December 15, 2017

Reference: Wateridge Village Phase 1B – Blocks 15, 22, and 24
Transportation Overview – Addendum No. 1
City File No.: D07-12-17-0111
Our File No.: 117121 (R-2017-205)

Drawing file: plan / All_Image Referencing_Site Plan Application_Image Reference_2017-12-22 Block 15 Site Plan D02-02-17-0081.PDF

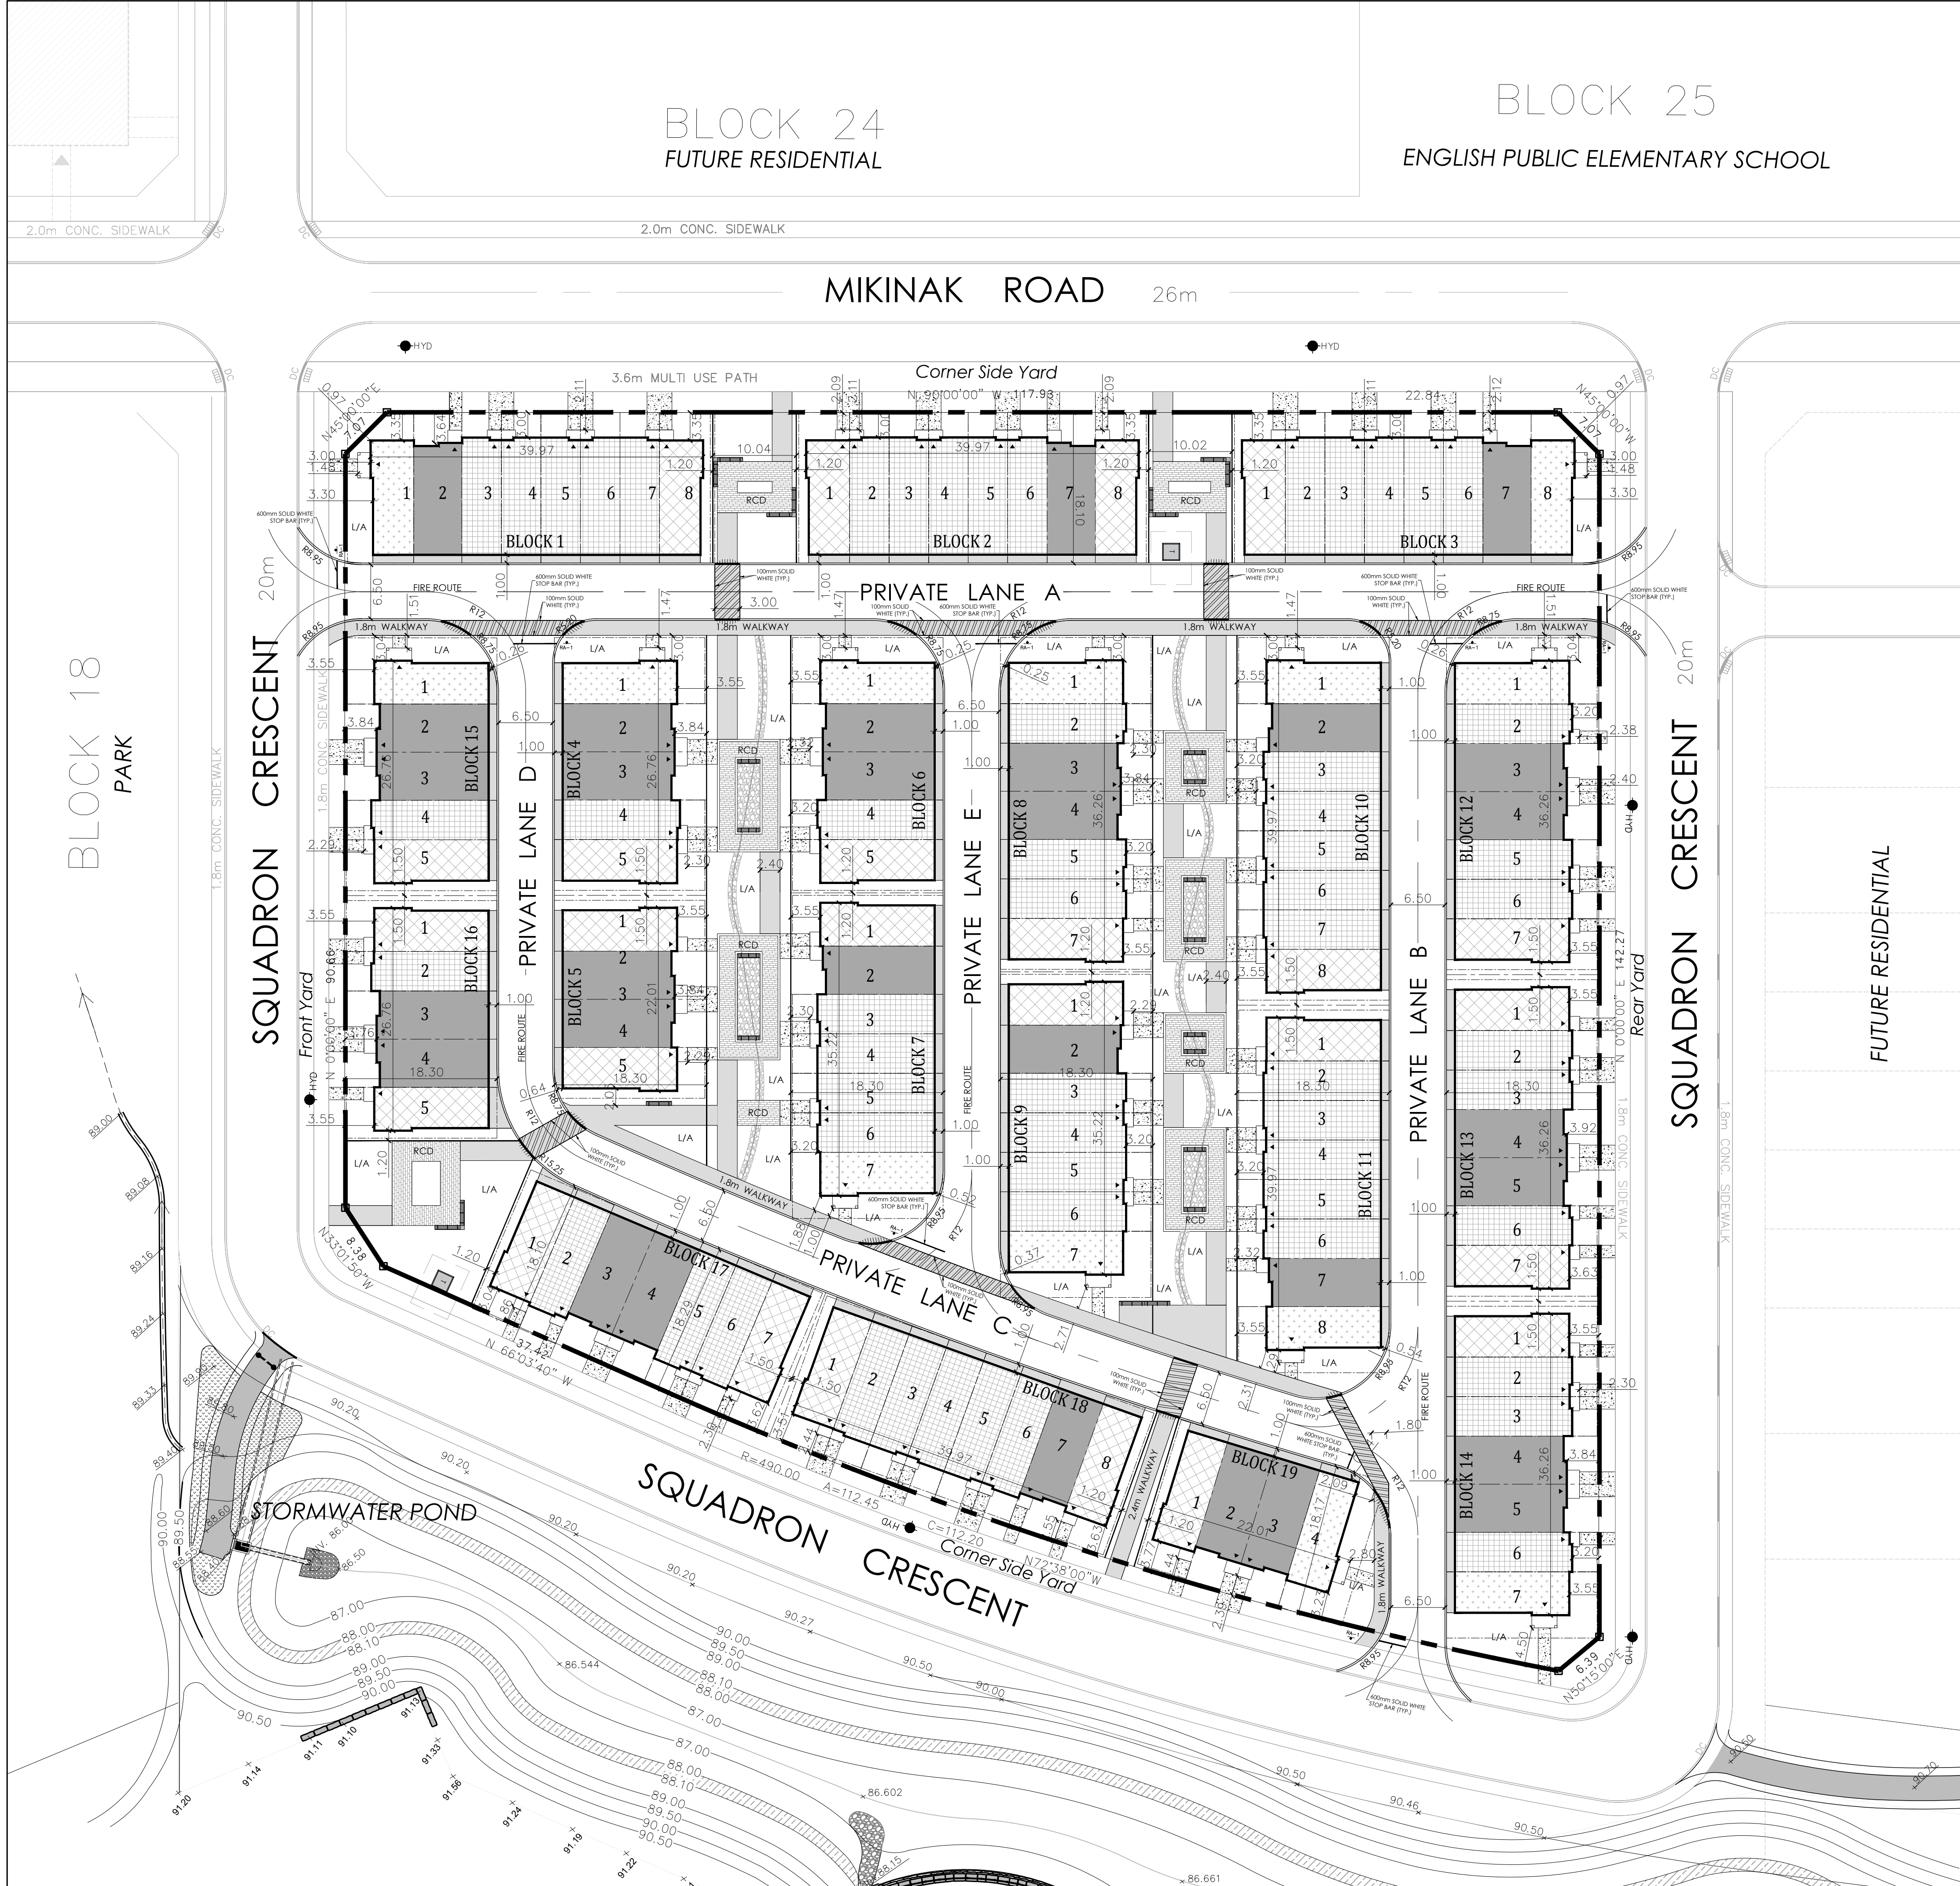
As requested by the City, the proposed on-site pavement marking and signage design is now reflected on the revised Site Plans.
